FG/134/13 Application

This is a formal objection to the above application

Client
PEUGEOT MOTOR COMPANY plc
Project
Yeomans
Littlehampton Road
Ferring
Worthing
BN12 6PB
Drawing
PROPOSED EXTERNAL LIGHT PLOT
Drawn by Date Scale
CY SEP 2013 1:200
Drawing No. Revision
1541/4

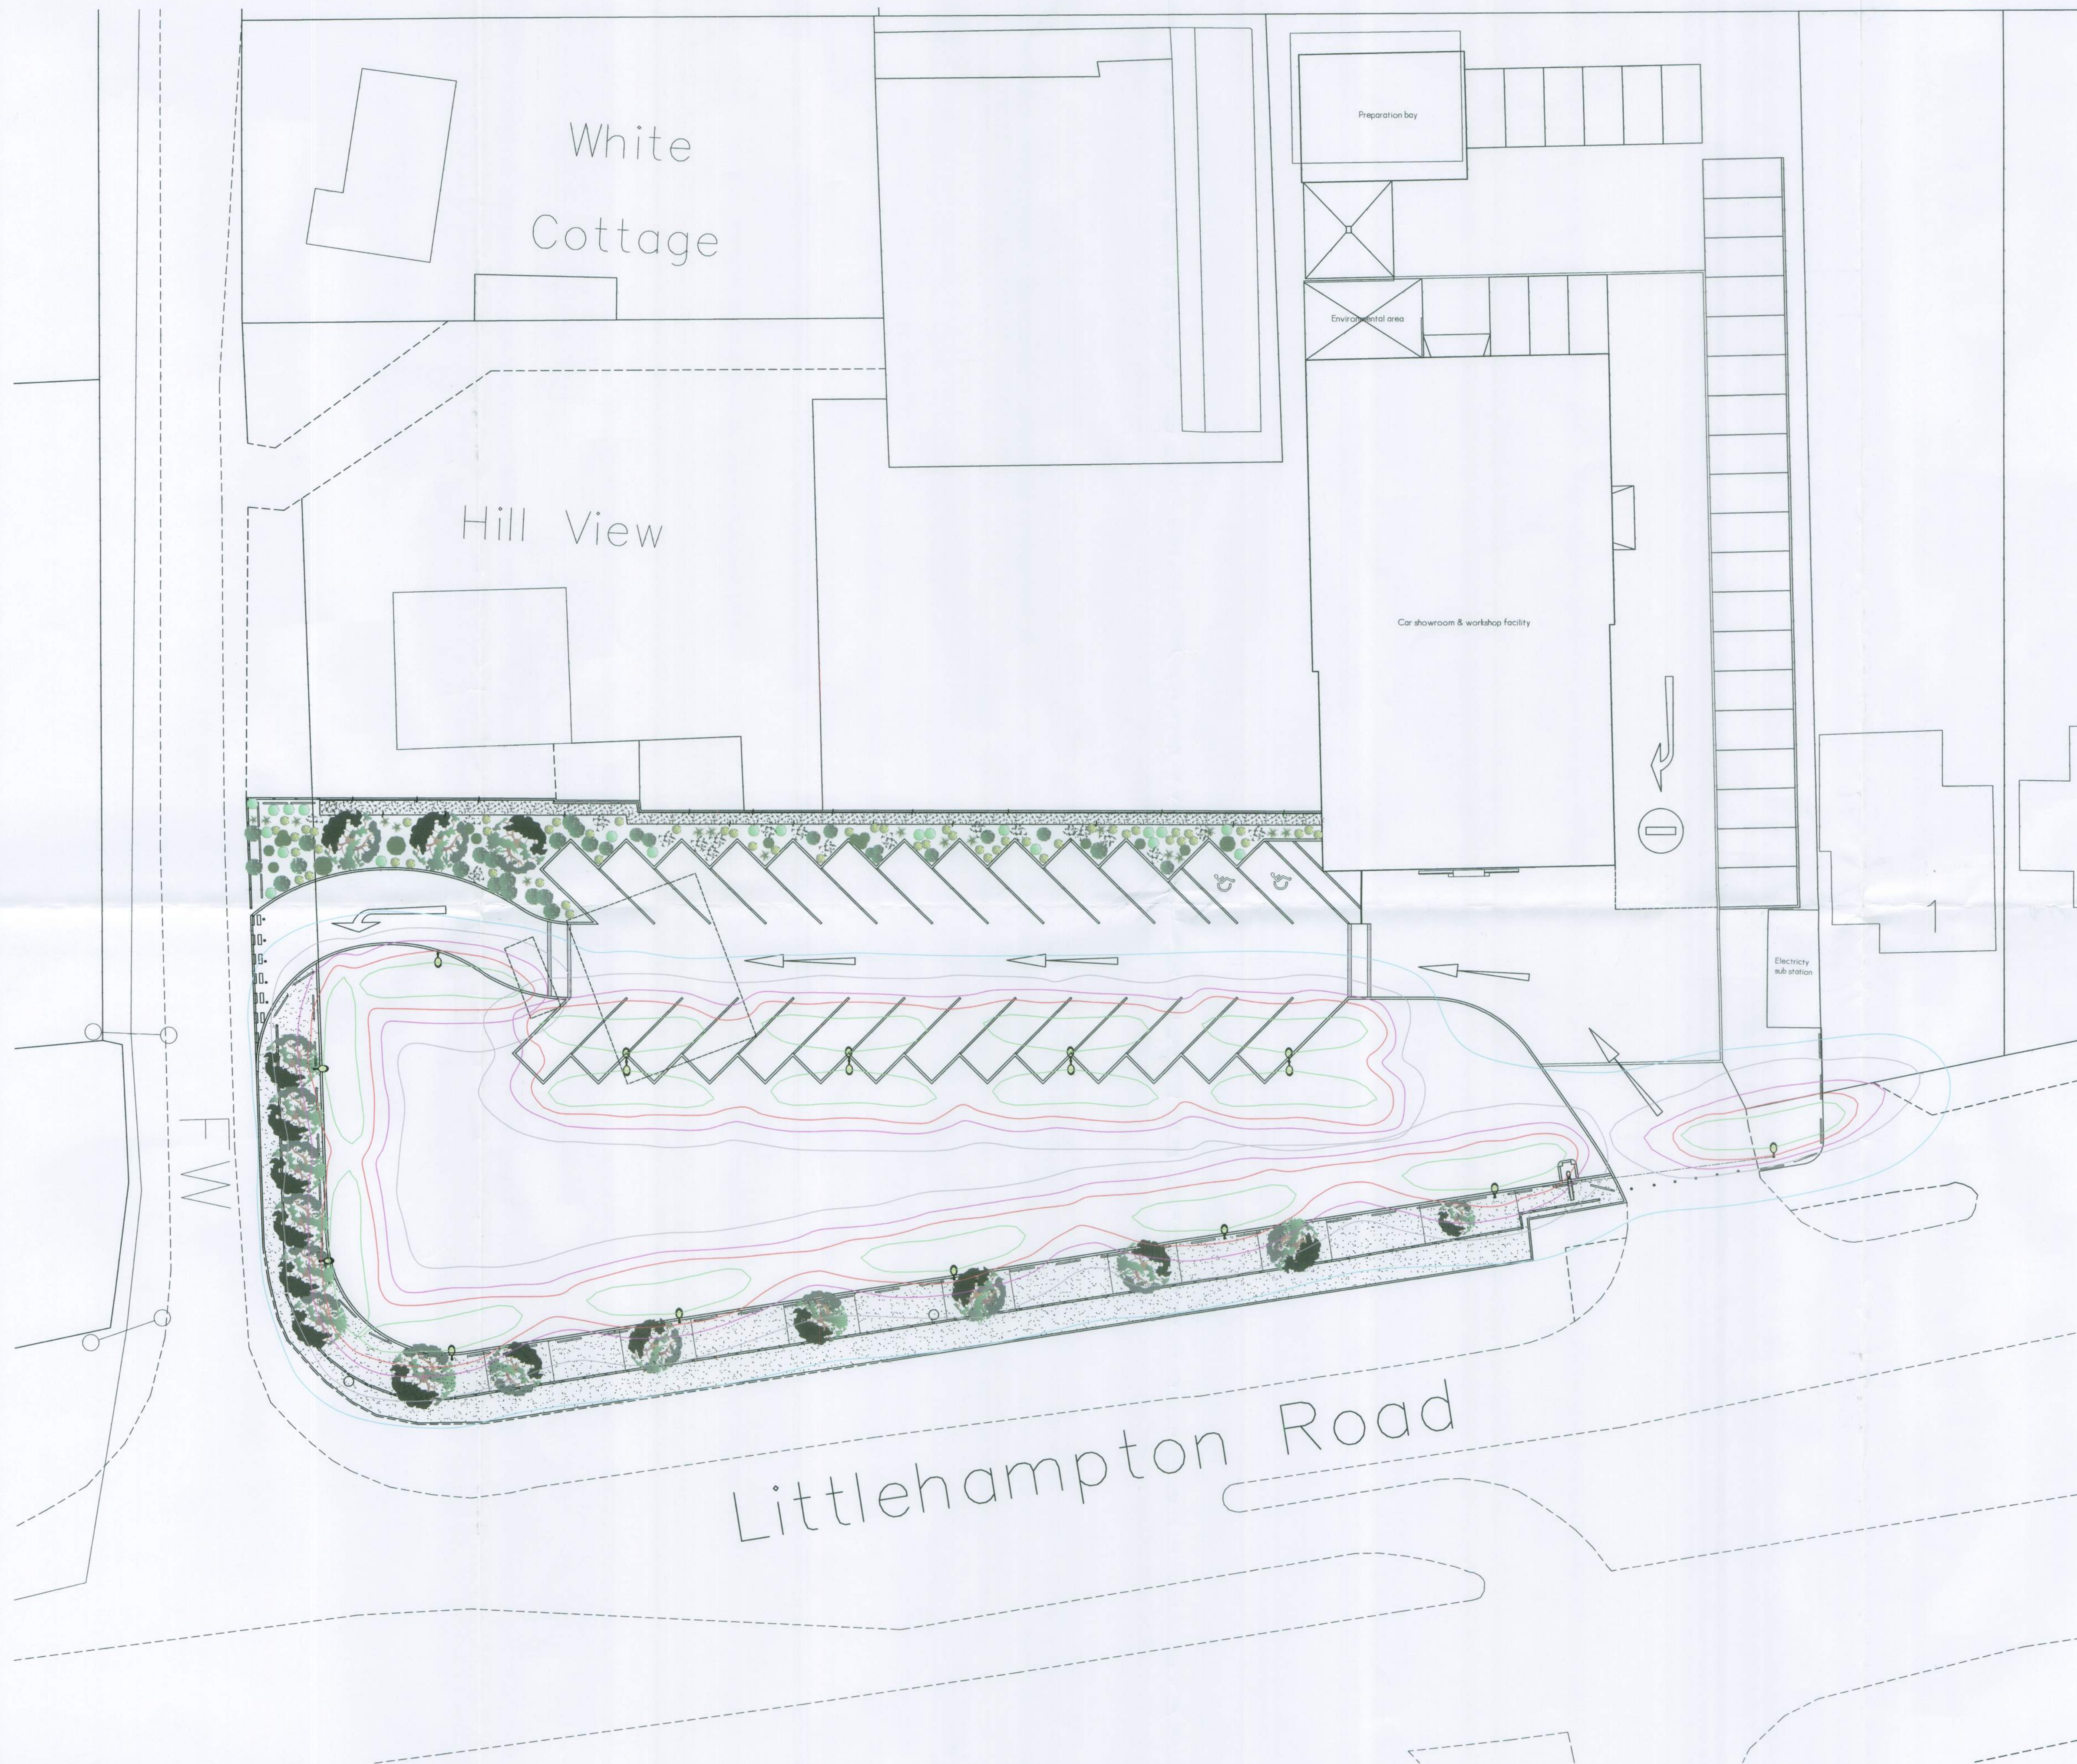
10 – Has any consideration been given to the residents in the near by bungalow behind the proposed site with high fencing and bright lights up 6m poles, surely the highway lighting would be sufficient.
